November 03, 2008

Re: Revision of Permit Drawings of the proposed development at
61 India Street, Portland, Maine

Please see the attached Architectural Drawings with revision number 2, addressing the items from your letter dated 10/16/08.

G1.1

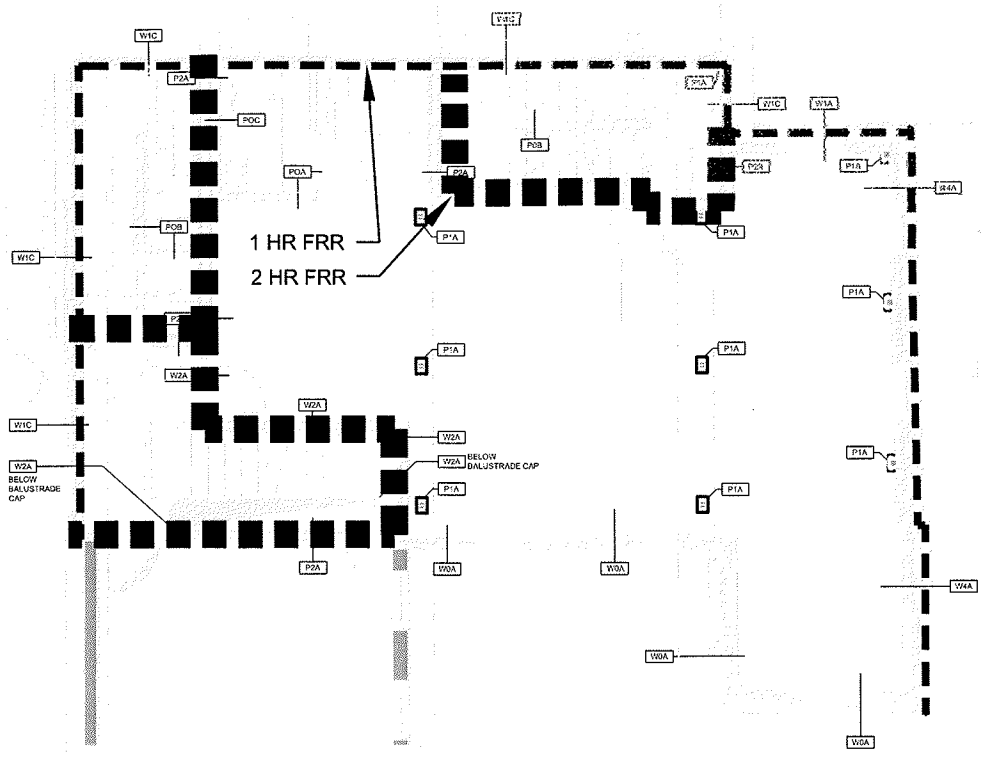
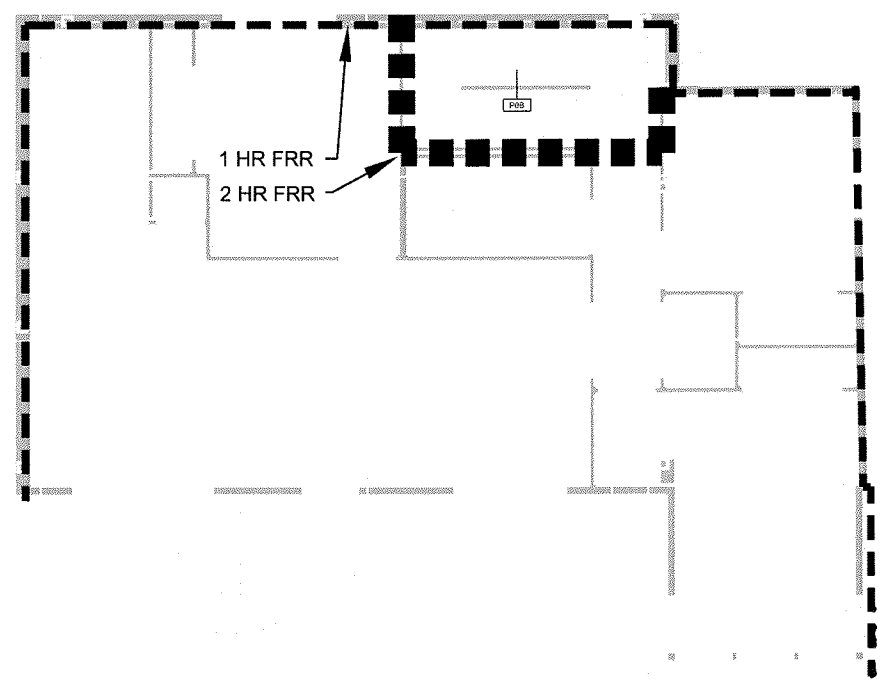
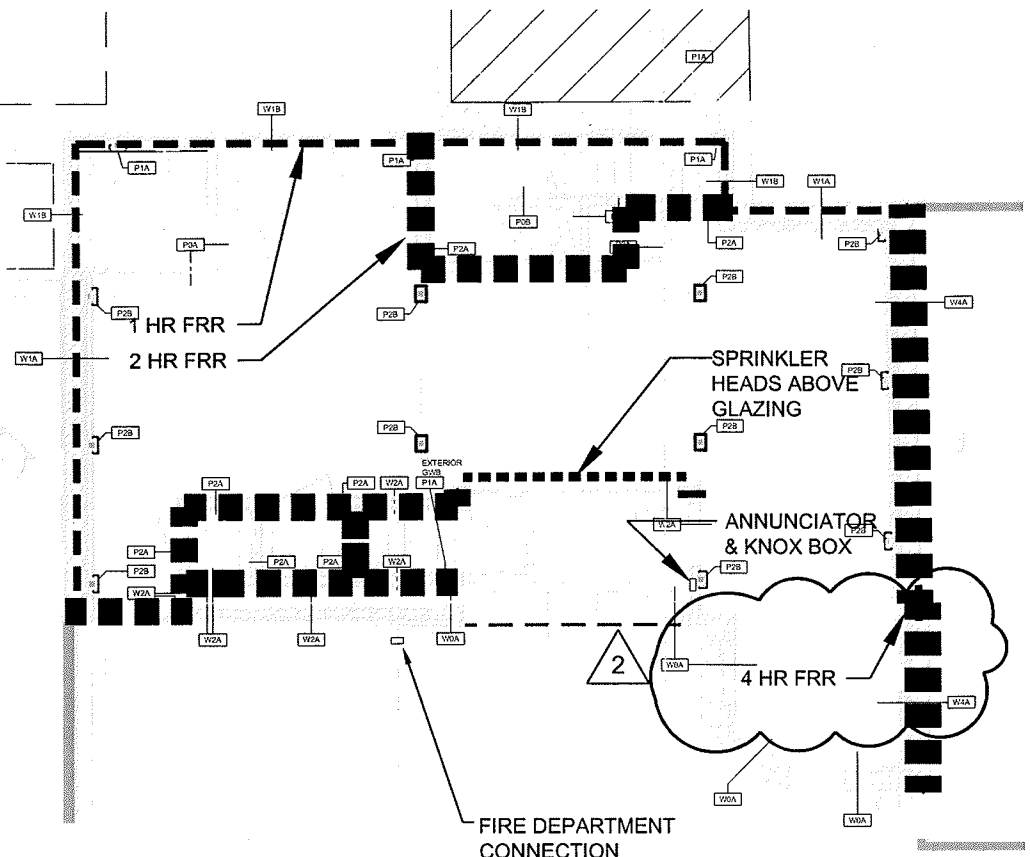
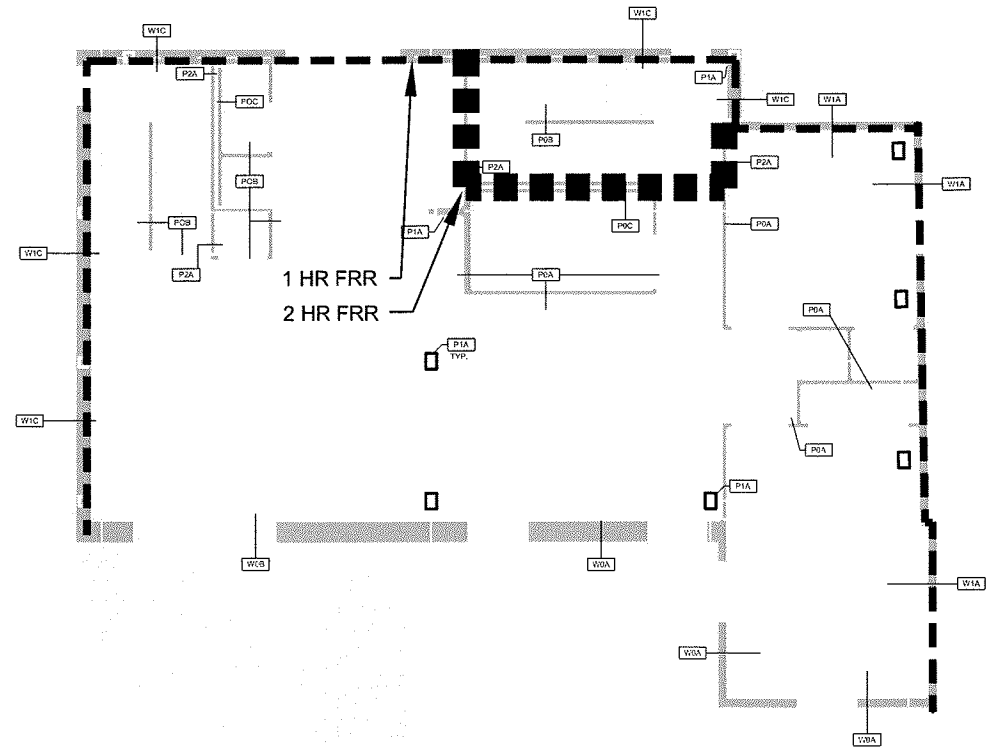
- Item 1: The structure is four stories
- Item 2: To be provided by Structural Engineer
- Item 3: Revised to include Mercantile occupancy, see G1.1
- Item 4: Calculations for floor areas meet 5A construction type as the new construction is separated from the existing structures with a fire barrier and considered a separate building.

A1.1

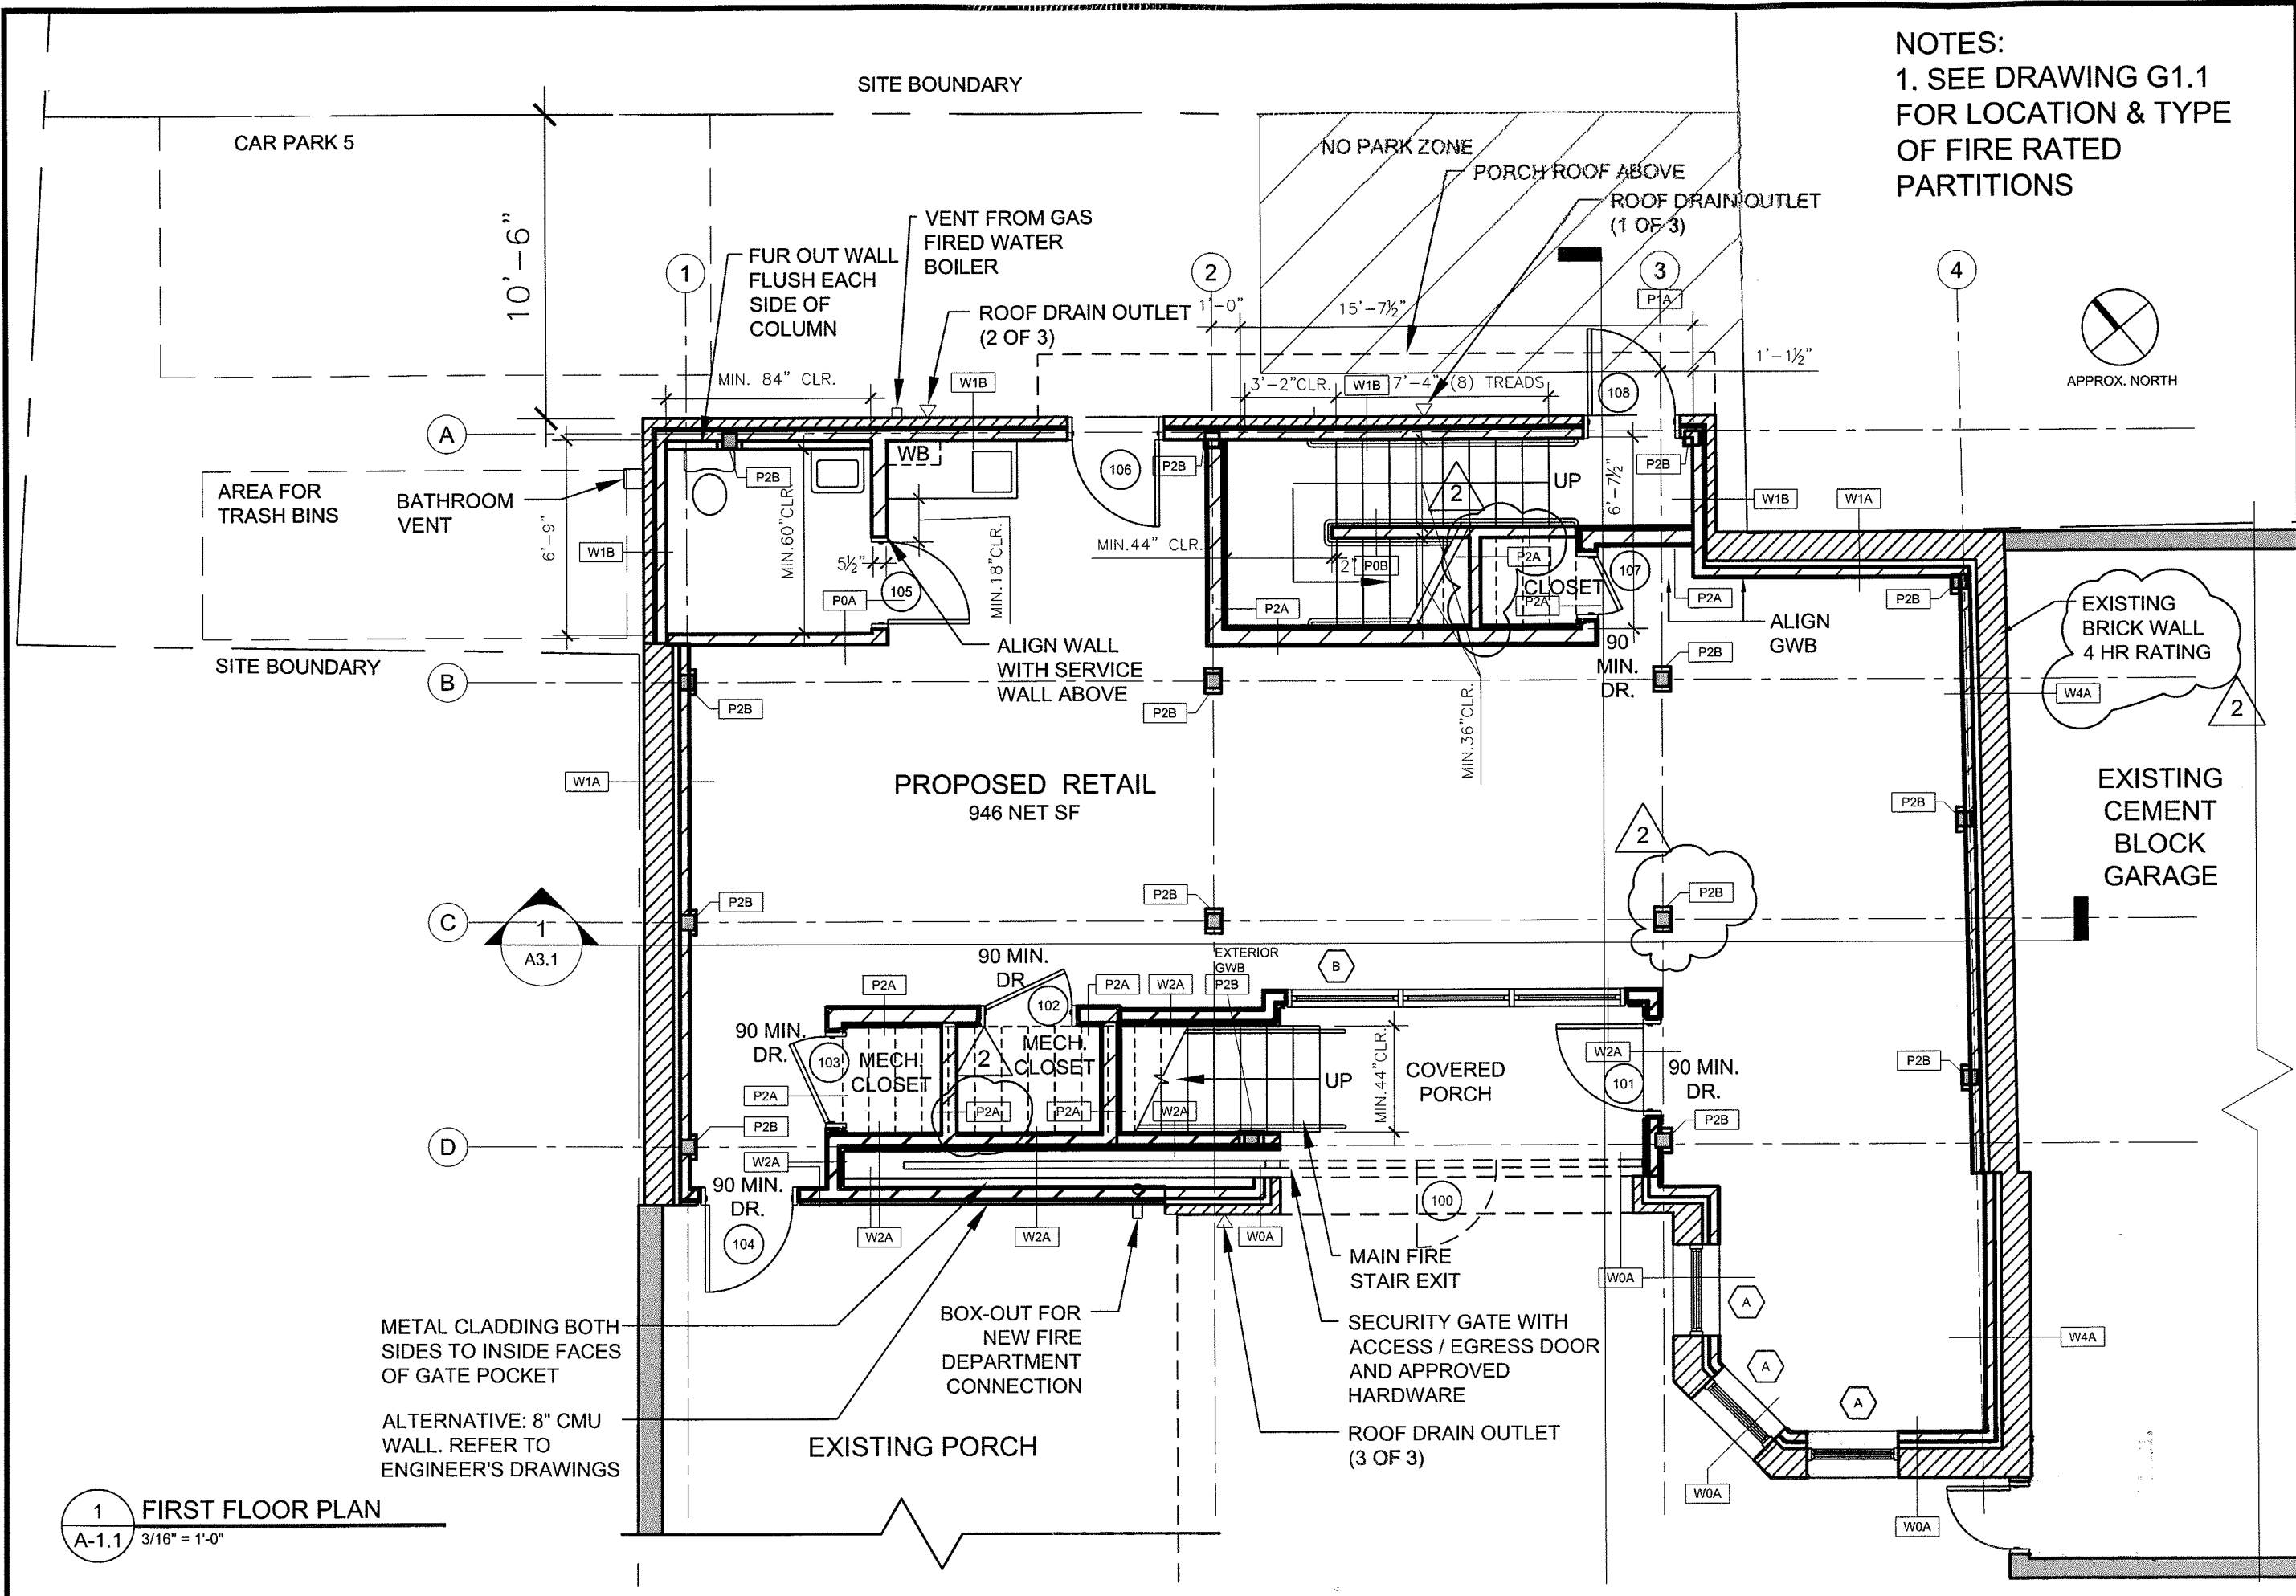
- Item 6: See the Building sections on sheets A3.1 and A3.2
- Item 7: The walls under the stairs have been revised to two hour fire walls see plans A1.1

A6.0

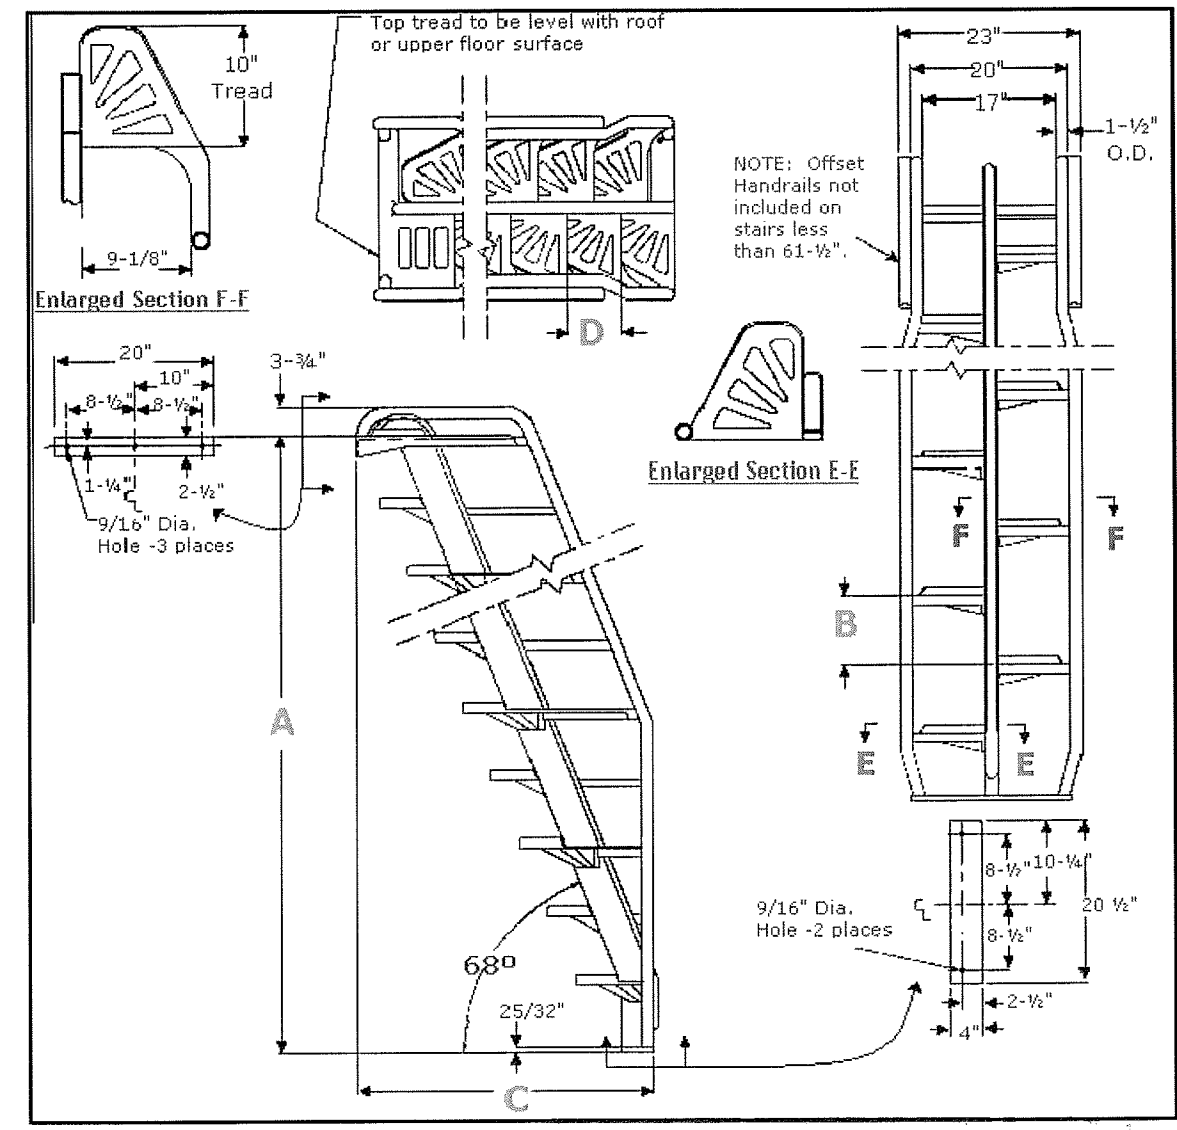
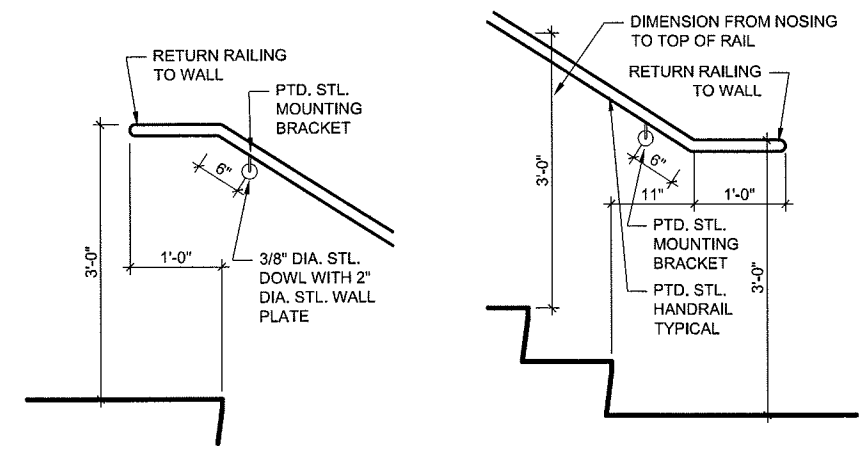
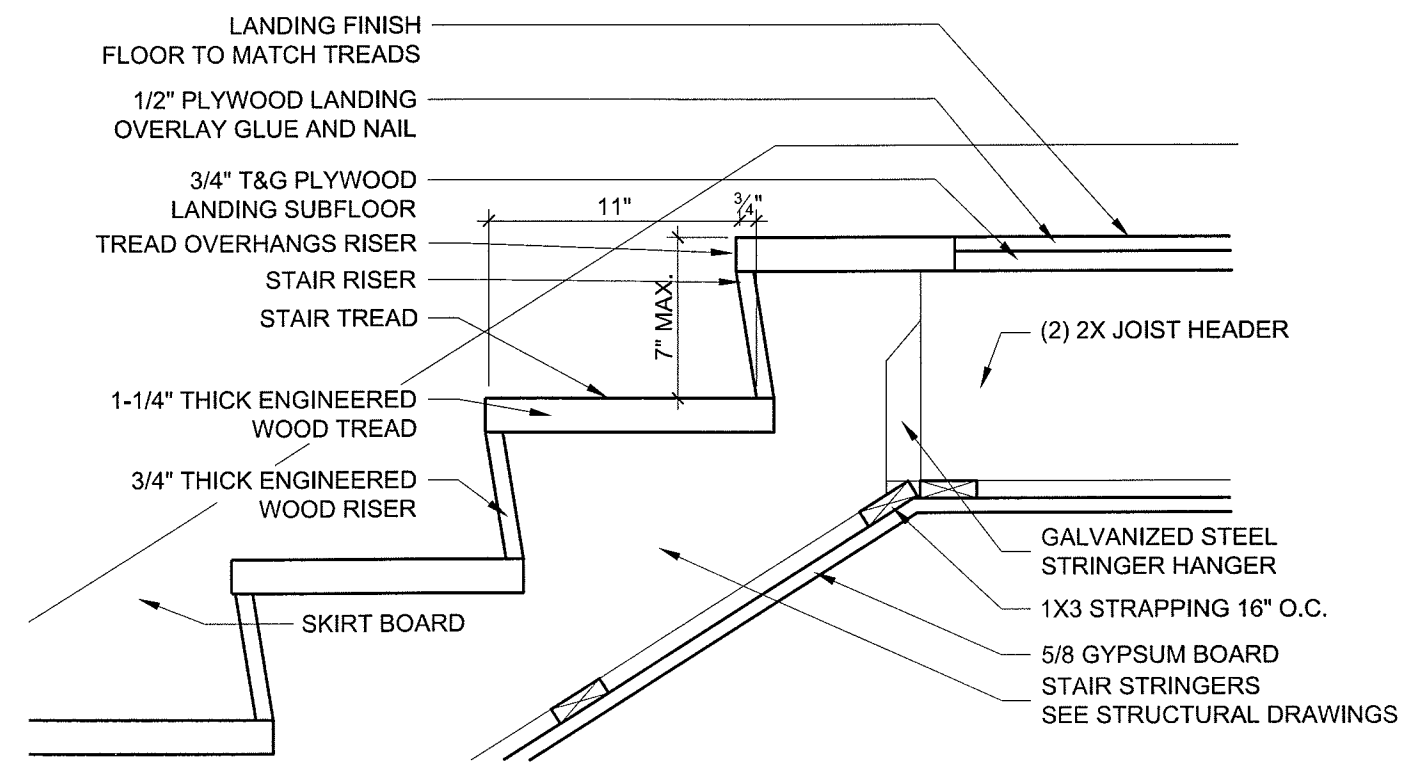
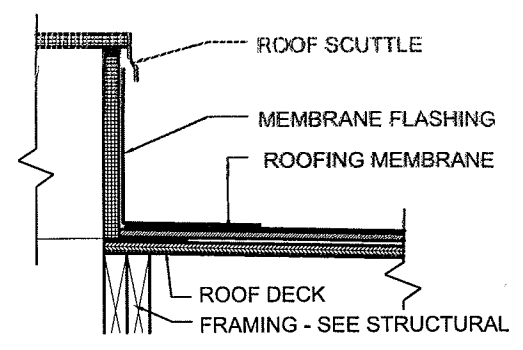
- Item 8: See Stair, railing, and alternating tread stair details on sheet A6.0
- Item 9: See Roof hatch detail on sheet A6.0, and roof plan on sheet A1.5
